**Lead Local Flood Authority**  
**Post Point CHN 215**  
**Hertfordshire County Council**  
**County Hall, Pegs Lane**  
**HERTFORD SG13 8DN**

**RE: 6/2023/0444/COND – Land to the North-East of King George V playing fields, Northaw Road East, Cuffley, Hertfordshire EN6 4RD**

Thank you for consulting us on the above application received on 6 March 2023, for the submission of details pursuant to condition 6 (surface water drainage), on planning permission S6/2015/1342/PP for the residential development of up to 121 dwellings, associated infrastructure, and a change of use from agricultural land to an extension of the King George V playing field.

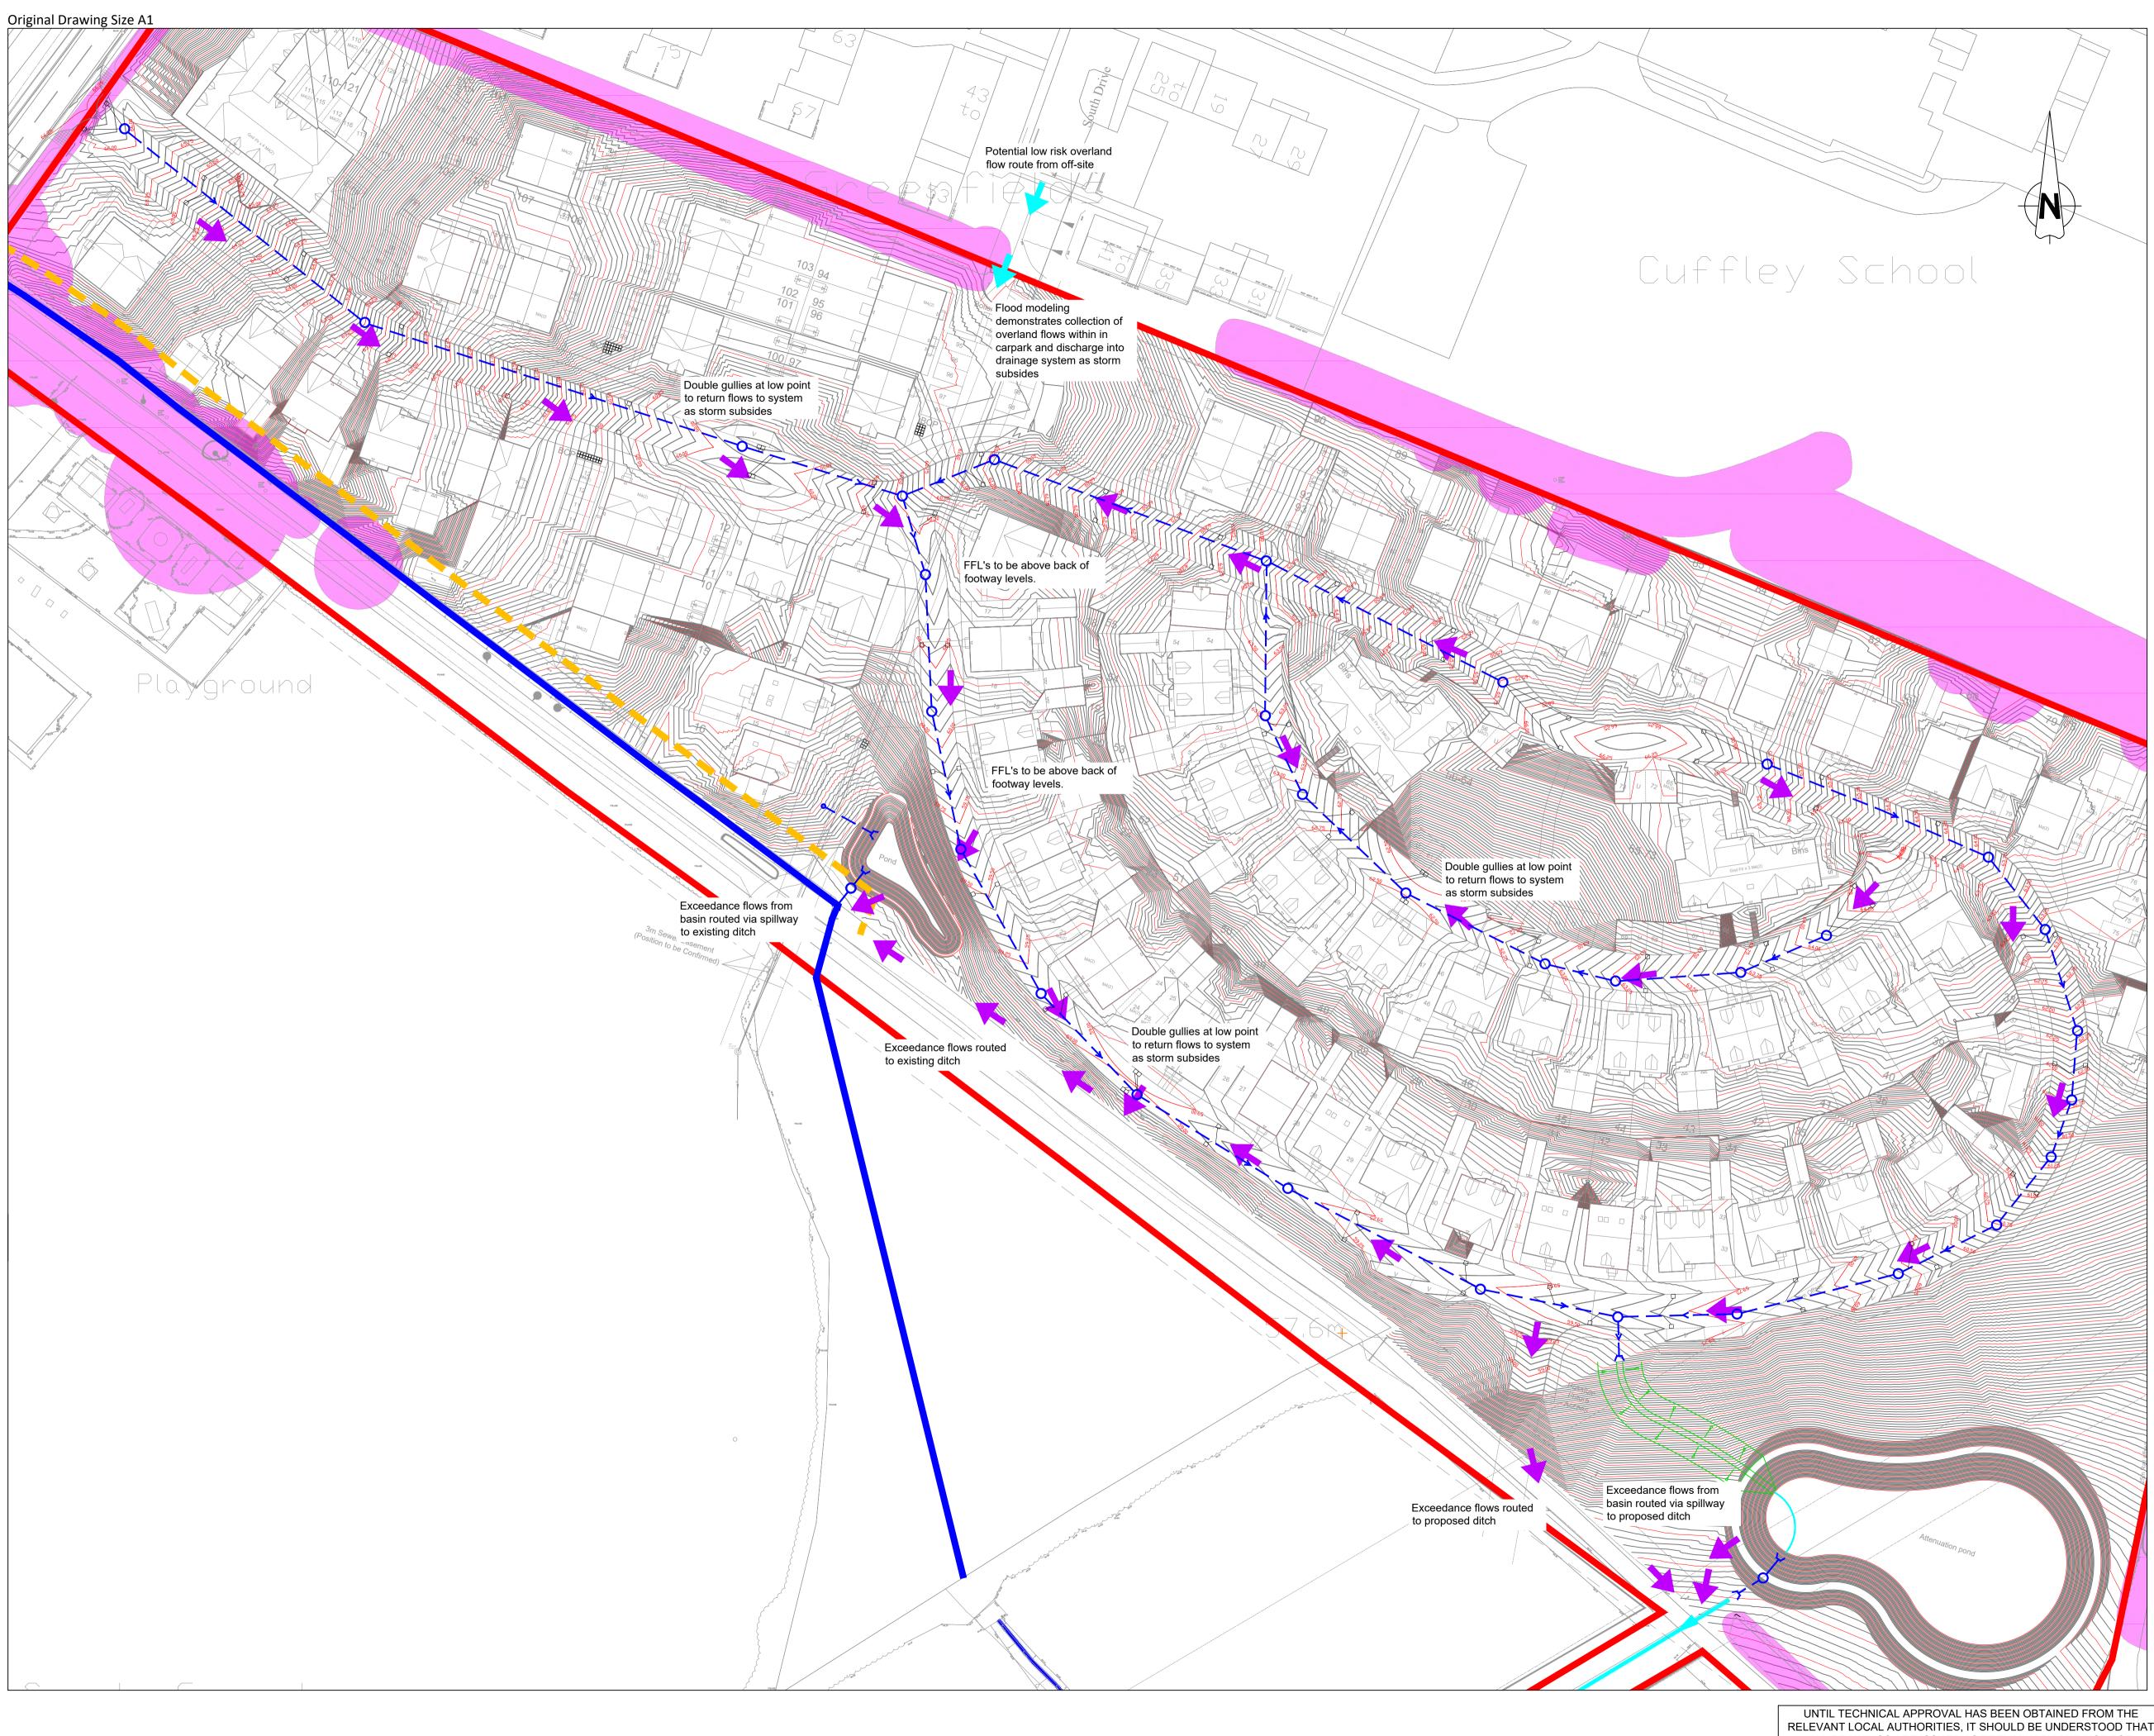
- In regard to condition 6 point 4 we require further information. We require justification as to whether the overland surface water flow path is considered separate from the drainage strategy or whether it will be accounted for in the strategy. In the applicants response to the LLFA objection, it is suggested that the 'overland surface water flows will be independent from the adoptable drainage system'. However, the applicant

further states that a 'low flow risk path flowing south from South Drive has been considered in the drainage strategy'. Despite being low risk, we would require suitable attenuation and storage to be accounted for with these volumes and flows to be accounted for in the drainage network modelling. If the overland surface water flow path from South drive is not part of the strategy, please clarify how this will be drained separately off the road and how it will not impact the proposed development and vulnerable areas such as residential dwellings.

- It is noted that cut off ditches are not being used, it is noted these were included to assist in the capture and management the surface water overland flow path originating off site that travels from north to south through the site. We request information how the flow path will be managed in detail; this is likely to require pre and post development modelling to demonstrate that there is no adverse risk of flooding and that the proposed development is safe for its lifetime.

Basin 1 - Section D-D (1:500)

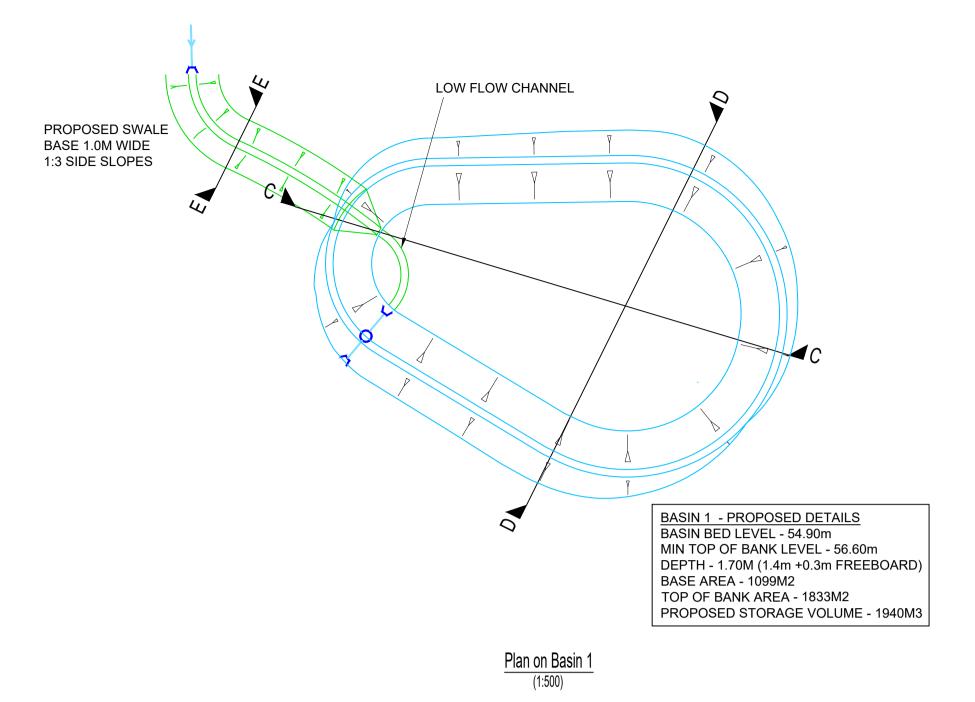
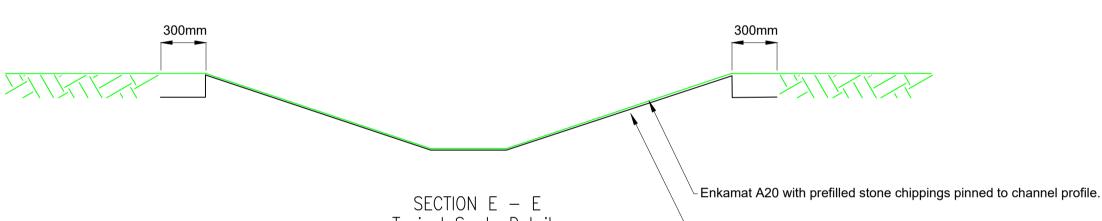
- Insufficient detail has been added to basin and swale drawings. We require, storage, volume, area and discharge rate to be included on these drawings.
